**City of Portland, Maine – Building or Use Permit Application** 389 Congress Street, 04101, Tel: (207) 874-8703, FAX: 874-8716

Location of Construction: <b>121 Middle Street</b>		Owner: <b>123 Middle St. Partnership</b>		Phone: <b>774-1030</b>		Permit No: <b>981394</b>	
Owner Address: <b>123 Middle Street</b>		Lessee/Buyer's Name: <b>Ram Harnden</b>		Phone:		Business Name:	
Contractor Name: <b>* Allied/Cook Construction</b>		Address: <b>PO Box 1396 Portland, ME 04104</b>		Phone:		Permit Issued: <b>DEC 11 1998</b>	
Past Use: <b>Office</b>		Proposed Use: <b>Office</b>		COST OF WORK: <b>\$ 18,000</b>		PERMIT FEE: <b>\$ 110.00</b>	
				FIRE DEPT. <input type="checkbox"/> Approved <input type="checkbox"/> Denied		INSPECTION: Use Group <b>B</b> Type <b>3A</b>	
				Signature:		Signature: <b>BOCA 95/11</b>	
Proposed Project Description:  <b>Tenant Fit Up. 1st Floor Right Side Interior renovations.</b>				PEDESTRIAN ACTIVITIES DISTRICT (P.A.D.) Action: <input type="checkbox"/> Approved <input type="checkbox"/> Approved with Conditions <input type="checkbox"/> Denied Signature: _____ Date: _____

## BUILDING PERMIT REPORT

DATE: 10 Dec. 98 ADDRESS: 121 Middle St. 1<sup>st</sup> Fl. Apt CBL

RAM/HARDEN  
121 MIDDLE STREET - 1ST FLOOR  
12/8/98  
old channel 8  
offices

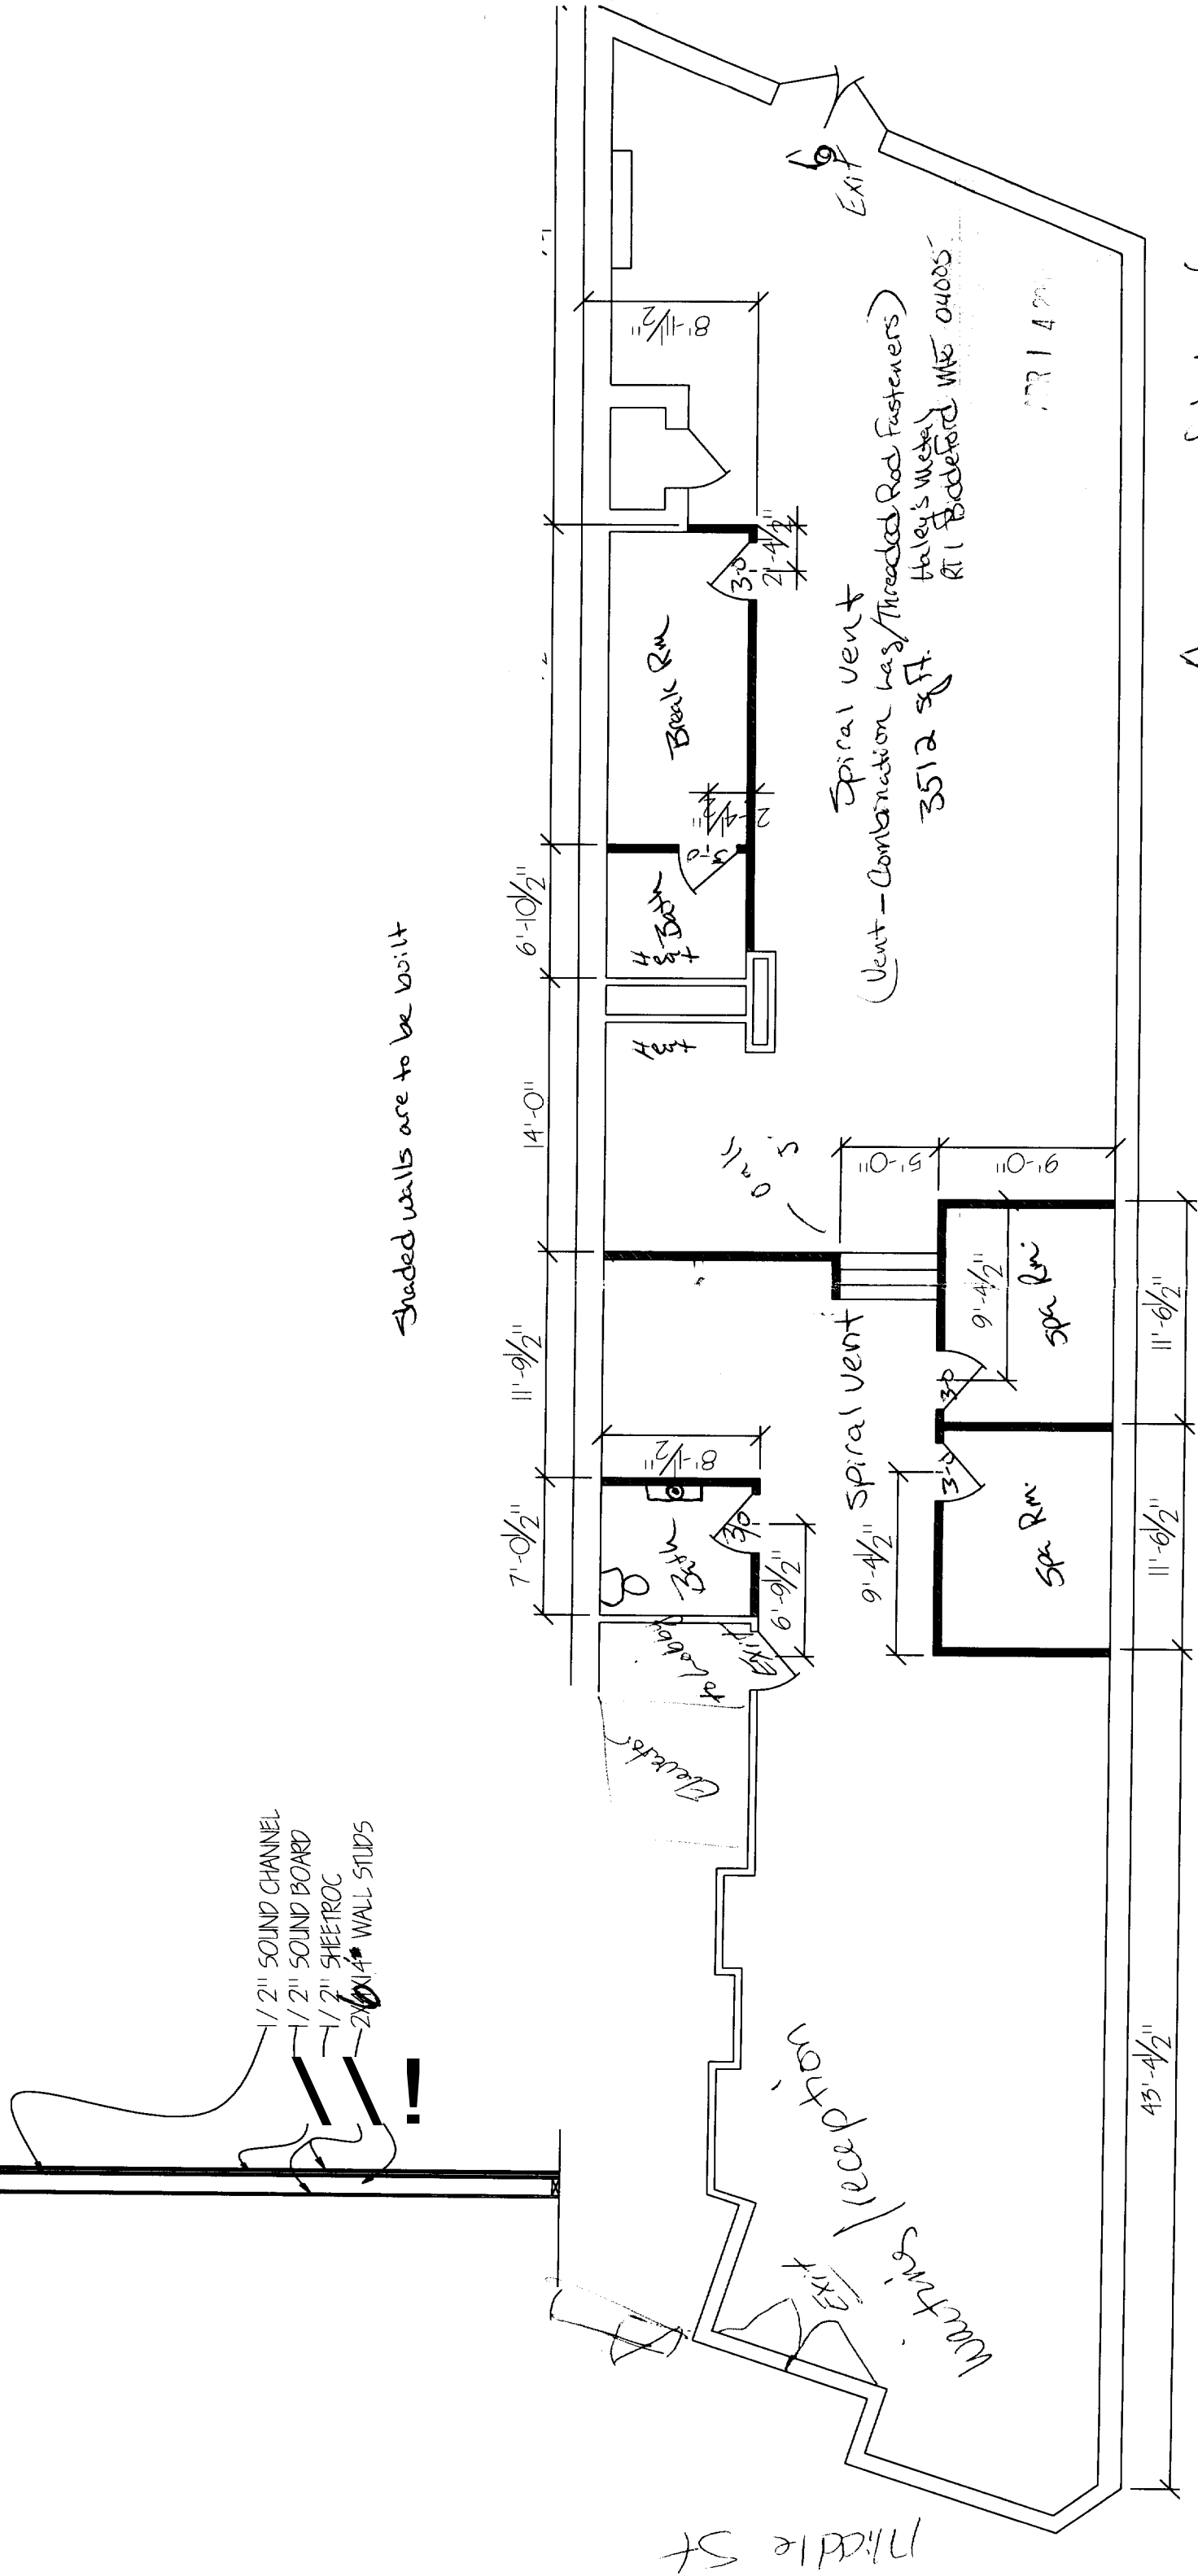
X 31. *Your plans did not show the detail of the proposed new walls. These walls must meet the requirements of the existing structure.*
